Your Ref: OWPC3227
Our Ref: LU/177/14/PL 10-06-2014
Please ask for:
Mr D Sullivan

Demolition of original dairy distribution depot and construction of 8 No. dwellings and ancilliary works. Resubmission following LU/298/13. This application may affect the character and appearance of the Littlehampton (East Street) Conservation Area.

The Old Dairy Behind 3 & 5 Church Street Littlehampton

SITE PLAN WITH DRAFT LEVELS
 PROPOSED RESIDENTIAL DEVELOPMENT
 THE OLD DAIRY, CHURCH STREET, LITTLEHAMPTON, SUSSEX.
 GRAHAM NICOLLS LIMITED, DESIGN + TECHNOLOGY, TEL/07990 522709

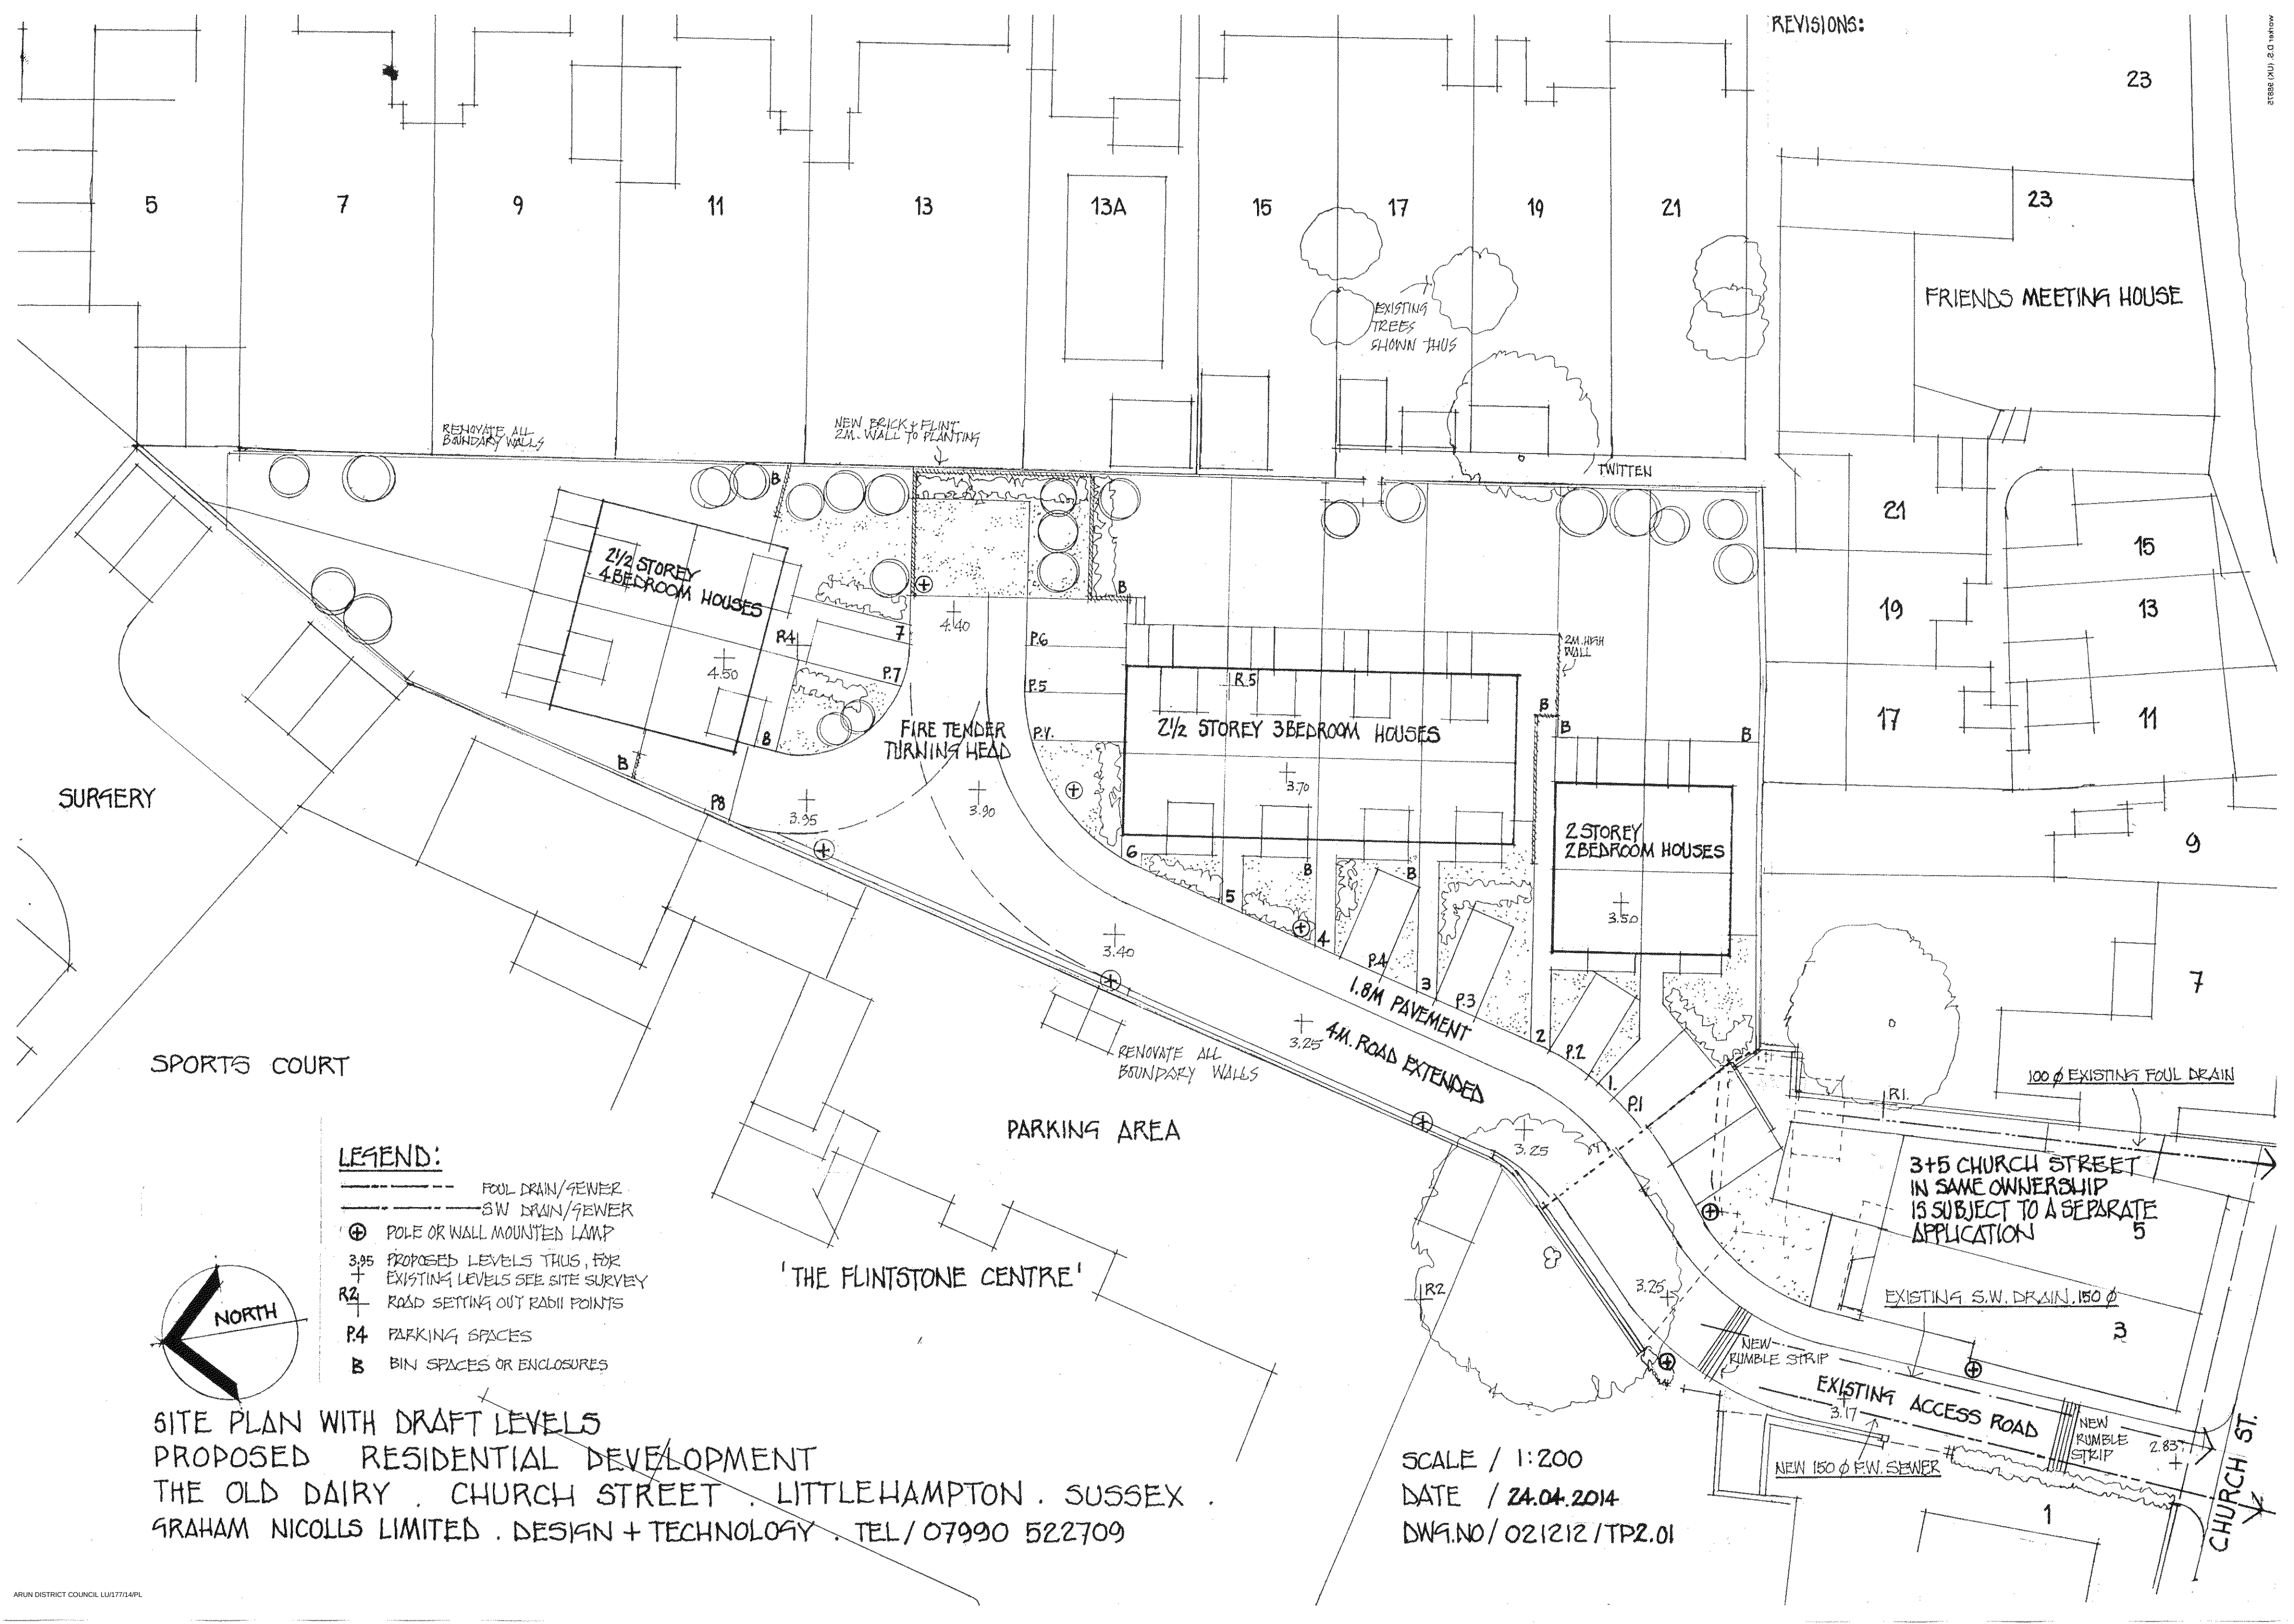
Whilst I have no general objection to the development I would like to clarify how the proposed wall between the back of my property and the new properties will be altered. There is a comment that the wall will be rebuilt and redesigned, however I don't see how that is possible without the owners consent nor any specific plan on how that flint and brick wall which forms part of the conservative area be altered. Please also bear in mind there is a right of way between the three properties along this wall out to Goda Road.

PLOTS 7 AND 8 FRONT AND REAR ELEVATIONS
THE OLD DAIRY LITTLEHAMPTON
GRAHAM NICOLLS LTD. BUILDING DESIGN + TECHNOLOGY

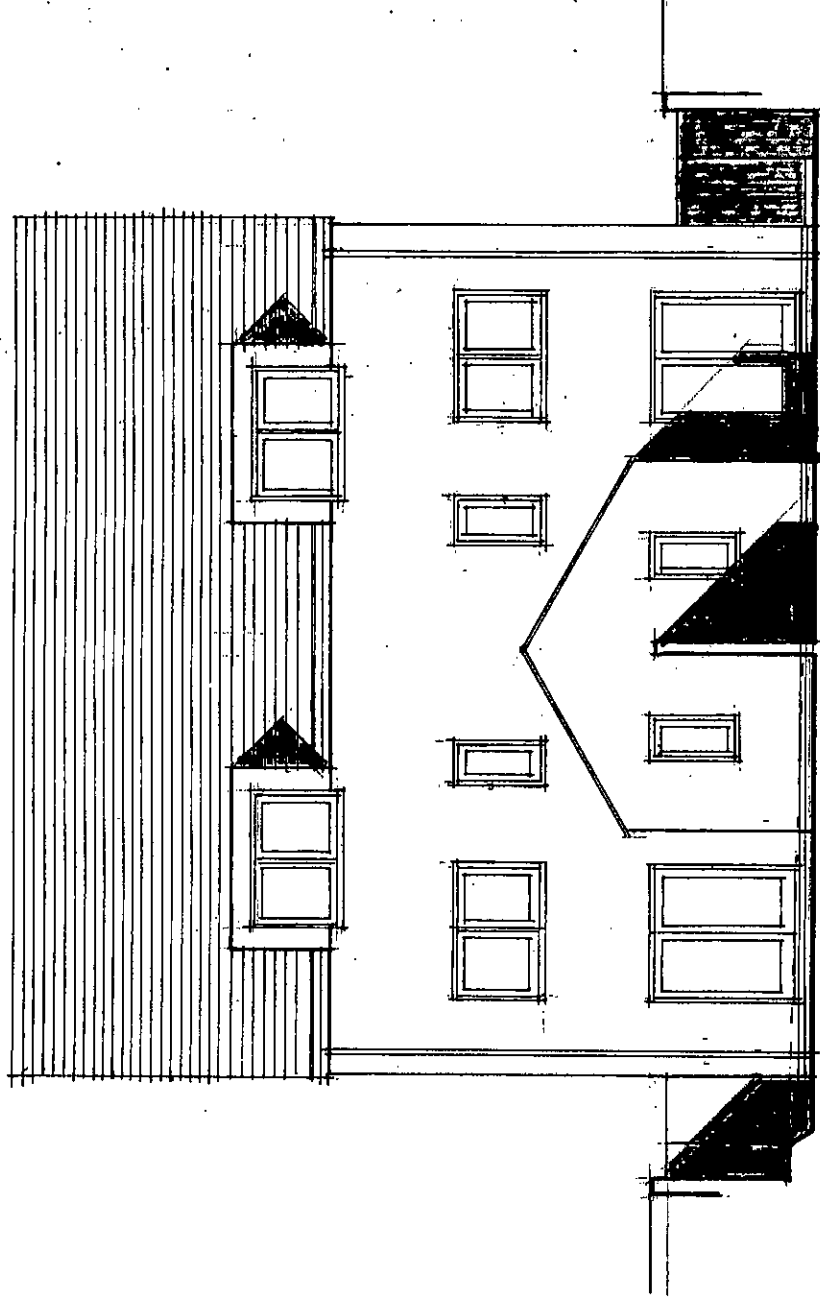
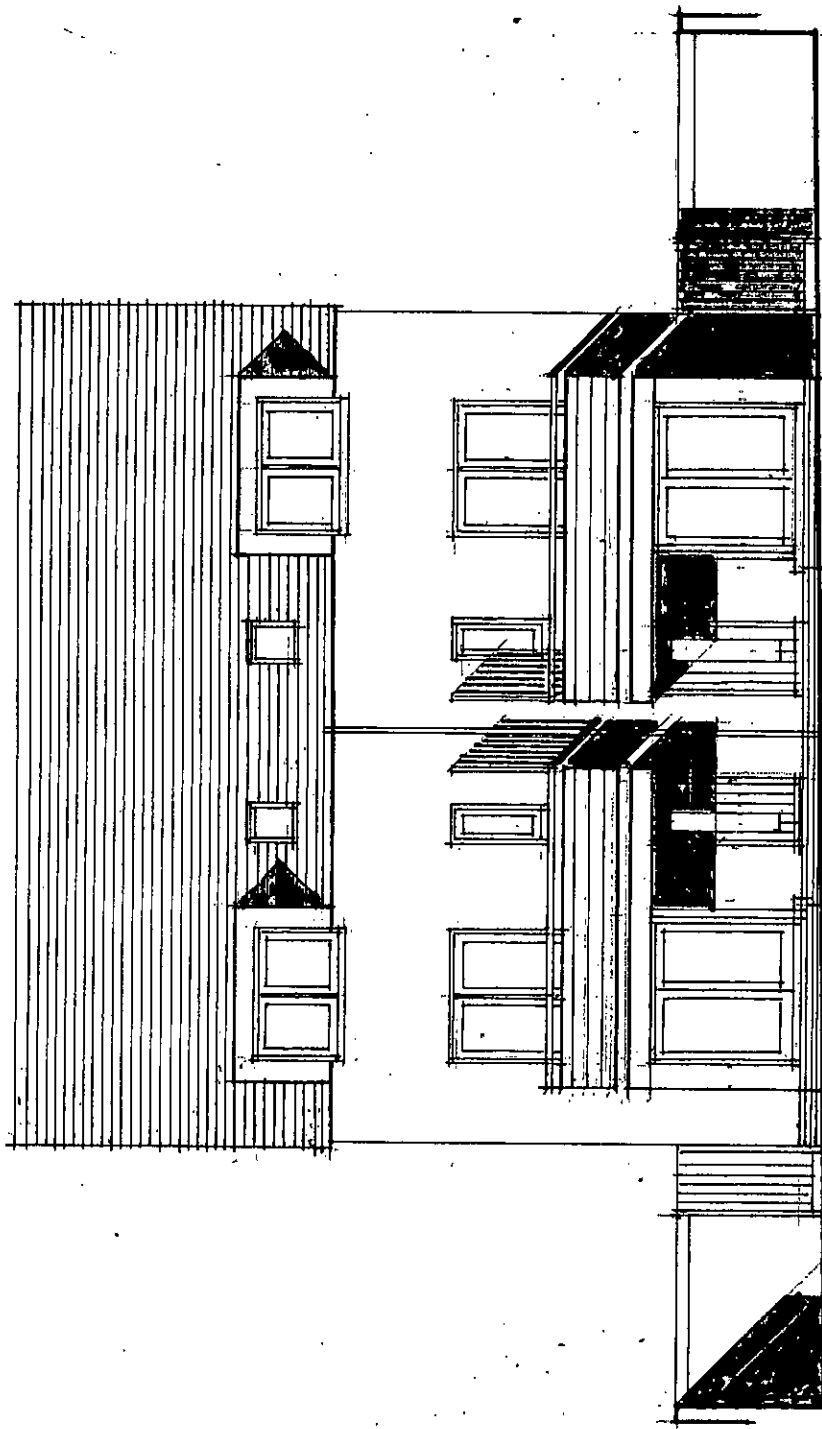
My final comment on the development is that of it's style relative to the existing buildings many of which are flint and brick and other earlier building methods. The use of blue engineering bricks seems wholly out of keeping with the neighbouring properties and I would ask that this element be reviewed and that council ensures that any new development bordering the properties be kept to a design in keeping with the conservation area it borders.
